Article 21 of the Town and Country Planning (General Development Procedure) Order 1995
Application for approval of details reserved by conditions 3, 4 and 7 of LY/1/13 - Landscaping,
drainage & bat owl habitat
Barn at Calceto Lyminster,,

Arun District Council have decided to **REFUSE details reserved by condition for the following reasons:**

Client	South by East Developments
Drawing Title	Drainage Layout

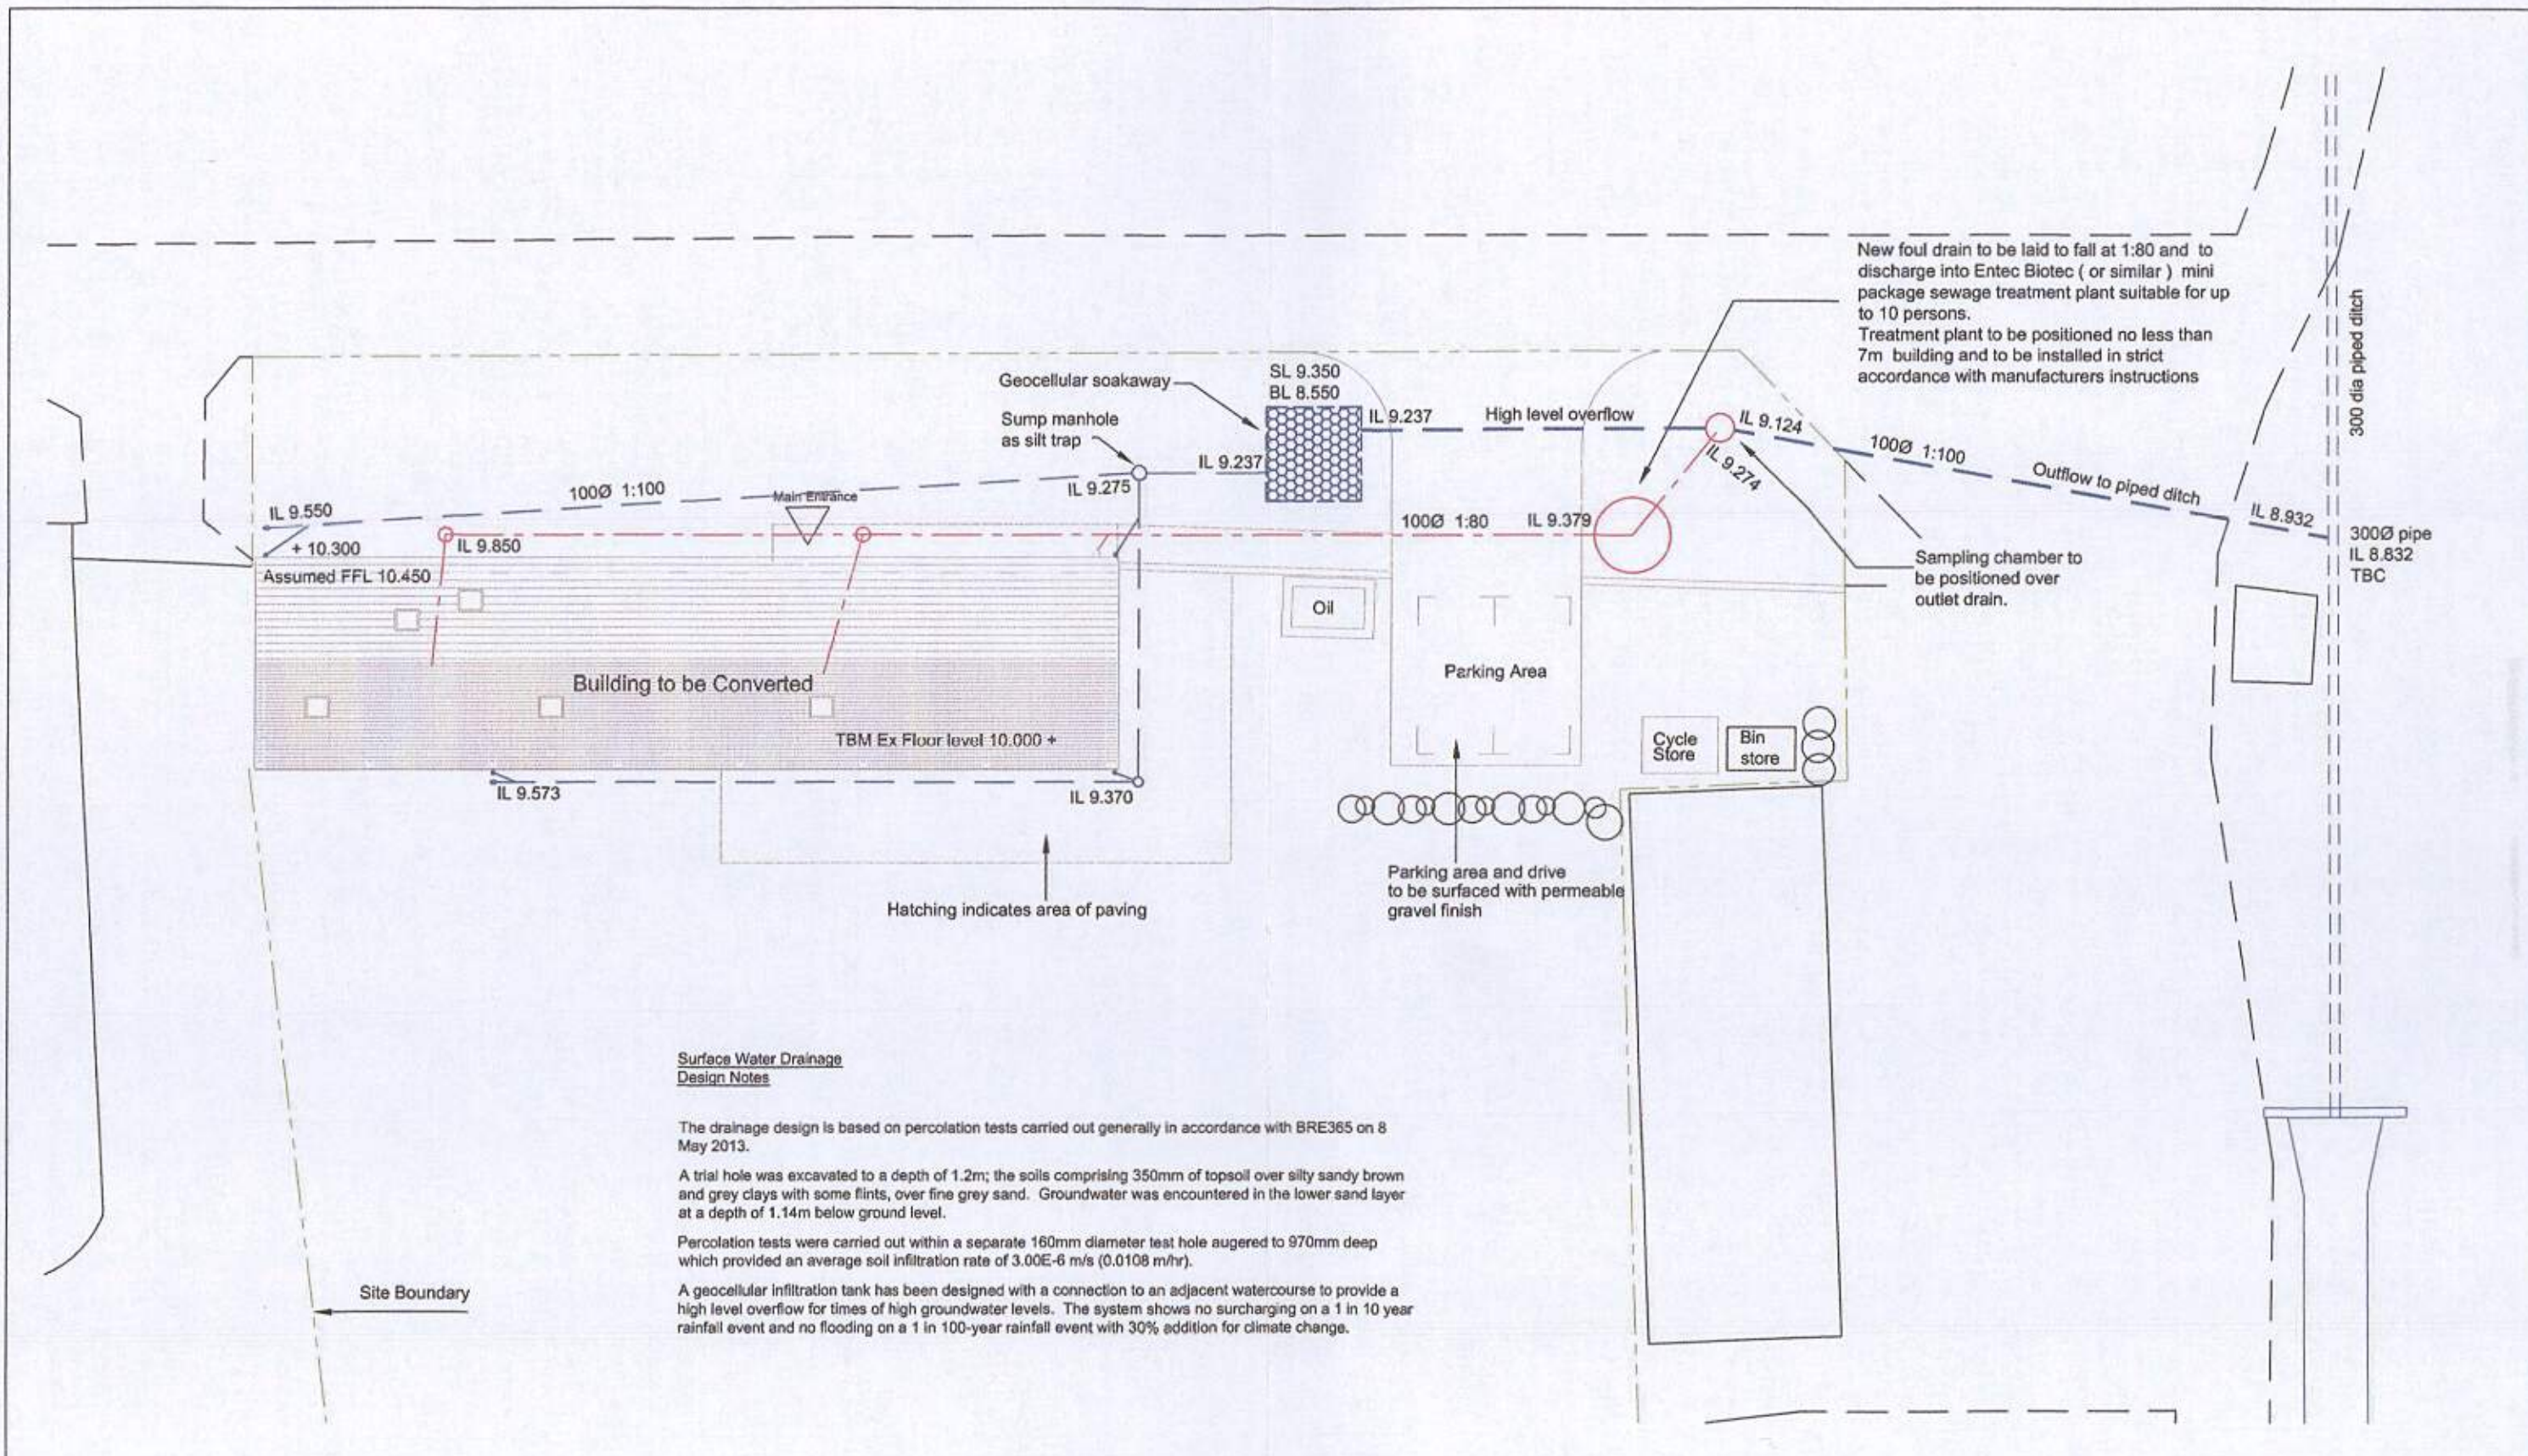
This condition cannot be discharged at this time since there is insufficient information to assess the application. The following additional information is required:

1. Data/calculations to prove the percolation rate.
2. Calculations for the soakaway design (1 in 10 year storm event and the 1 in 100 year storm event including 30% allowance for climate change)

Due to the fact that the percolation testing and groundwater monitoring were carried out in May 2013 (ie. just outside the recognised winter period), an appropriate safety factor should be applied to the design to allow for potentially poorer percolation rates and higher groundwater levels that are experienced during the winter months. Please note that the overflow should only operate in events beyond the 1 in 100 year storm.
